The Coal
Authority

Re: Planning application 2024/60/92031/E

Outline application for erection of residential development, adoptable road and public open space at Headlands Works, Headlands Road, Liversedge, WF15 7NT

The Coal Authority response: SUBSTANTIVE CONCERN

**MWA DRAWING NO. RSHR-MWA-XX-XX-DR-A-  
0003\_PROPOSED SITE LAYOUT (REV P8) SHOWING MINE  
SHAFT POSITIONS**

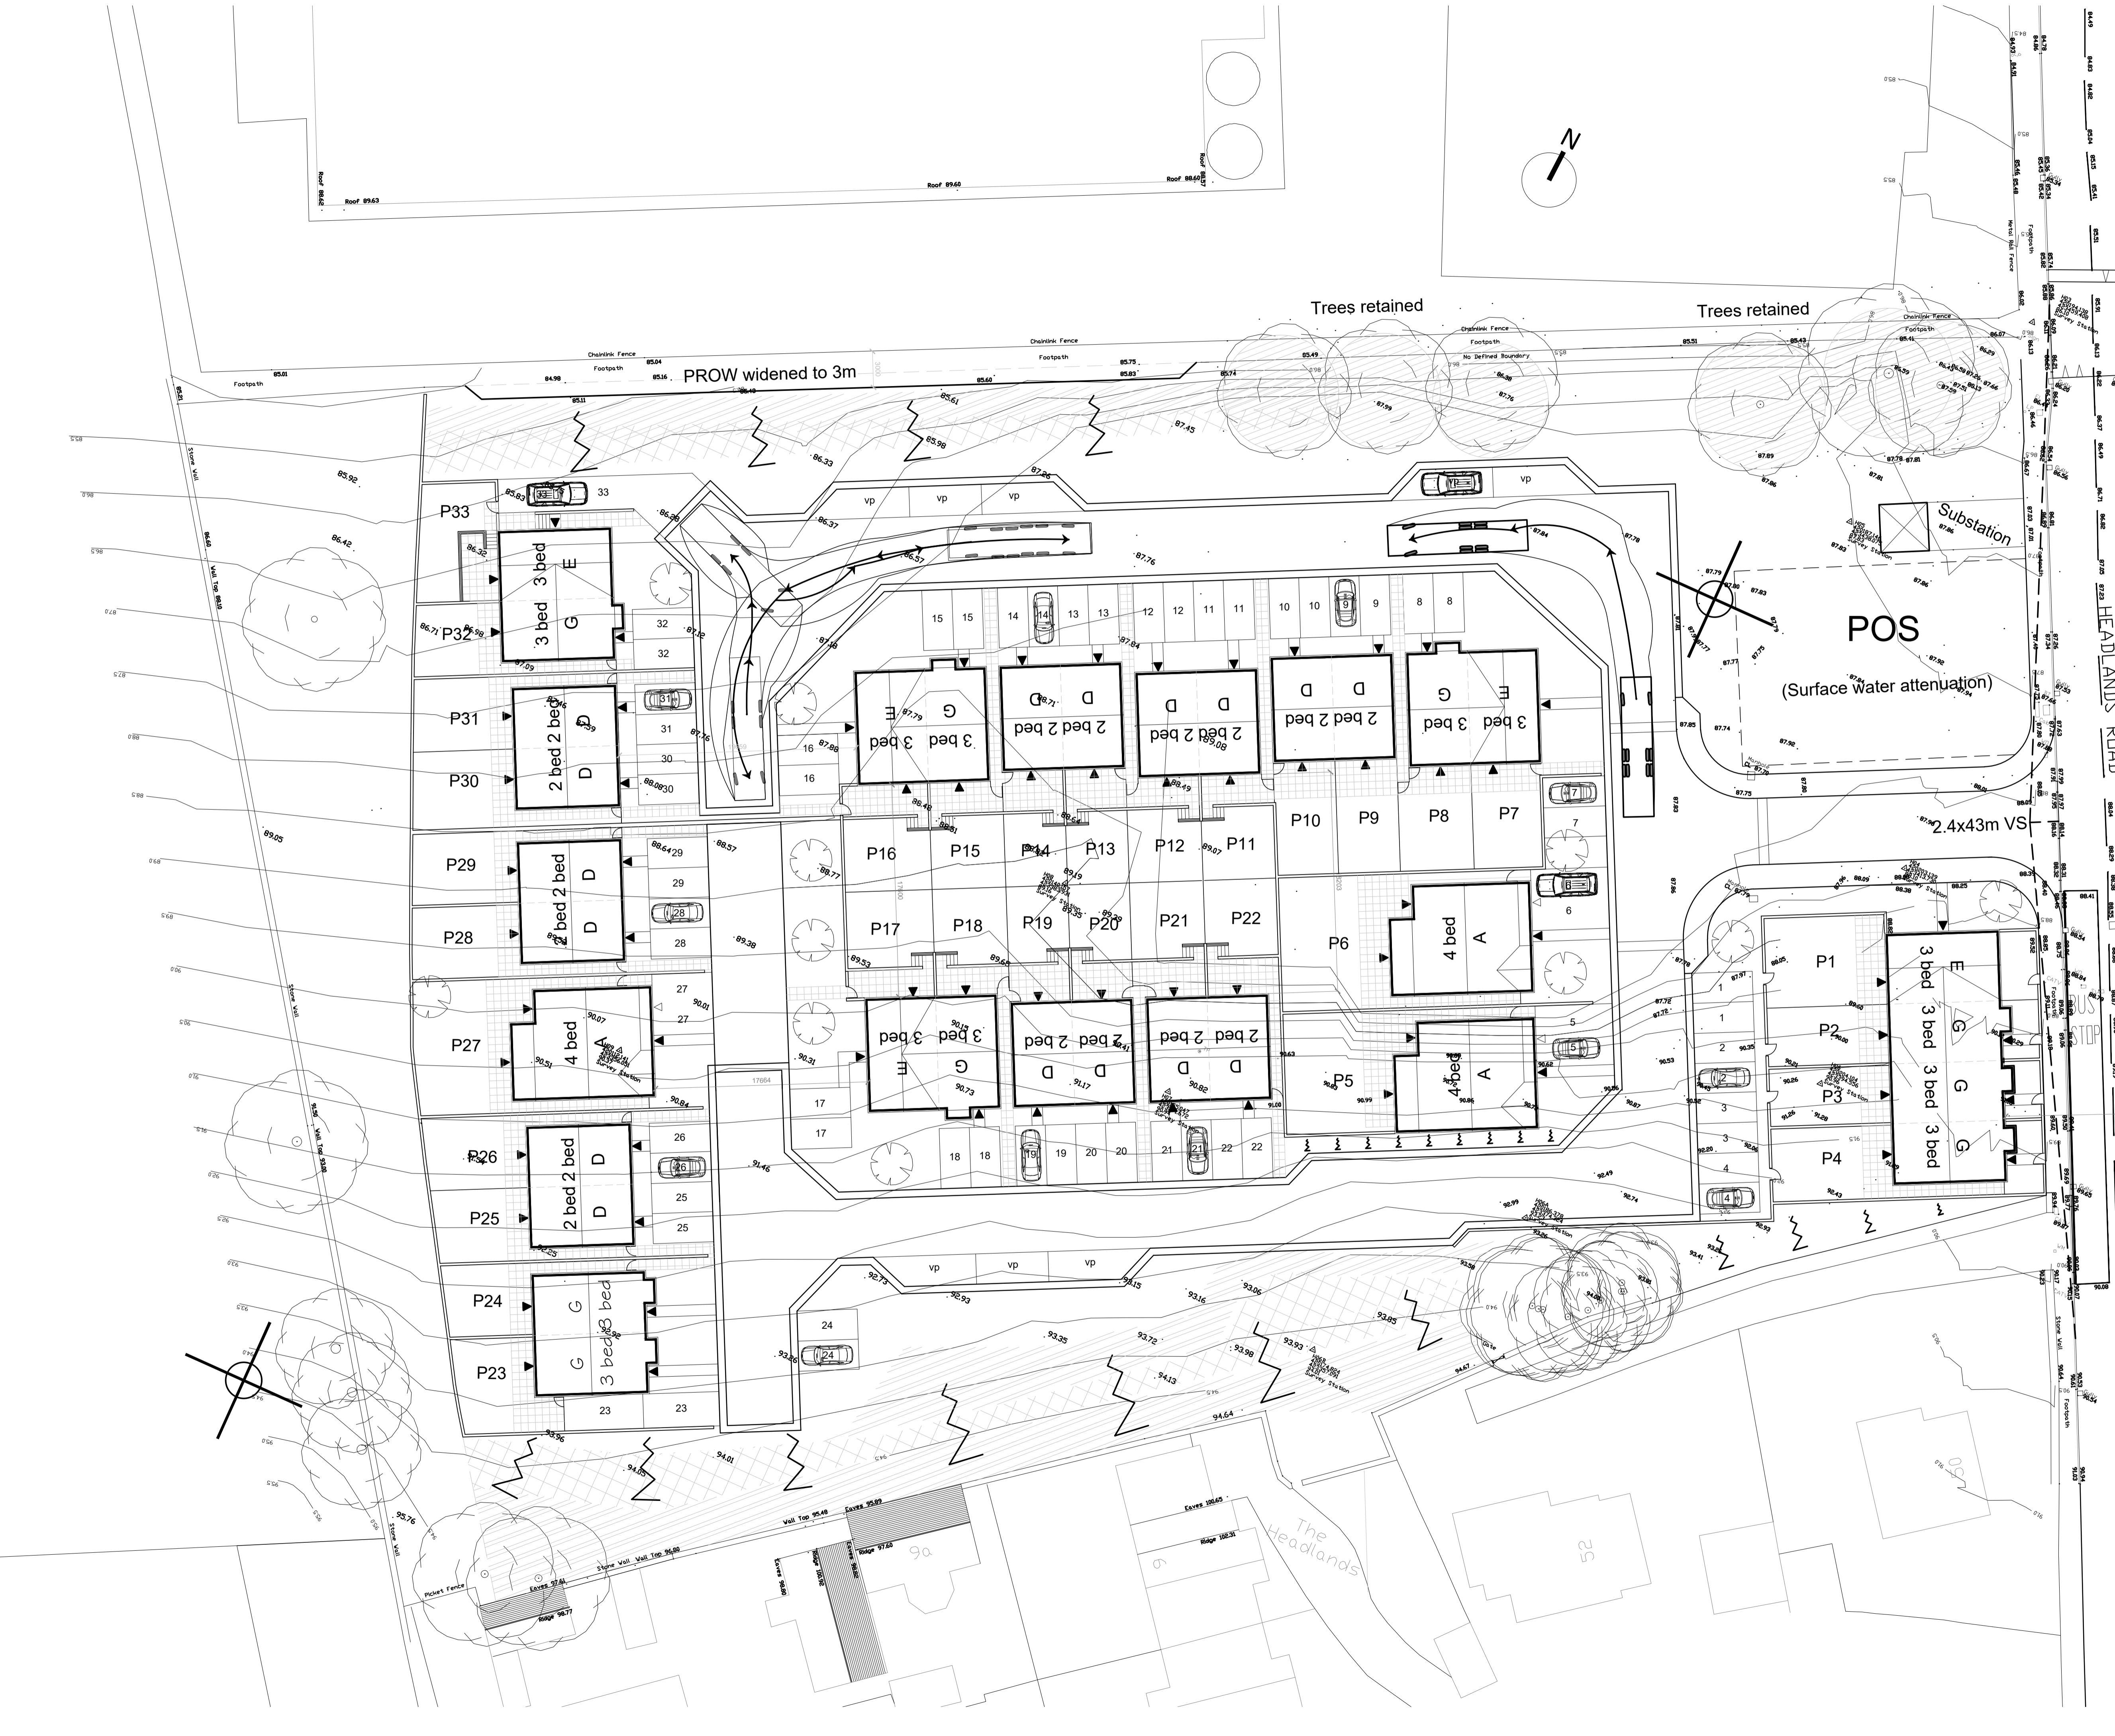
We acknowledge that the applicant is seeking outline permission for the proposed development, however, we note that they are also seeking approval of the layout of development at this stage. Whilst the recorded mine shafts and their associated zones of influence are not shown on the Proposed Site Plan, taking into account the potential departure distances for the shafts, the potential zones of influence of these features could encroach beneath the footprints of proposed built development. This would conflict with our adopted policy.

The information gained from these site investigations will enable the position of the on-site shaft to be identified and the extent of the zone of influences of this shaft and the off-site shaft to be calculated. This will allow any necessary revisions to be made to the site layout to ensure that the built development is sited in a manner which avoids the shafts and their zones of influence. These details should be clearly shown on a revised Proposed Site Layout drawing.
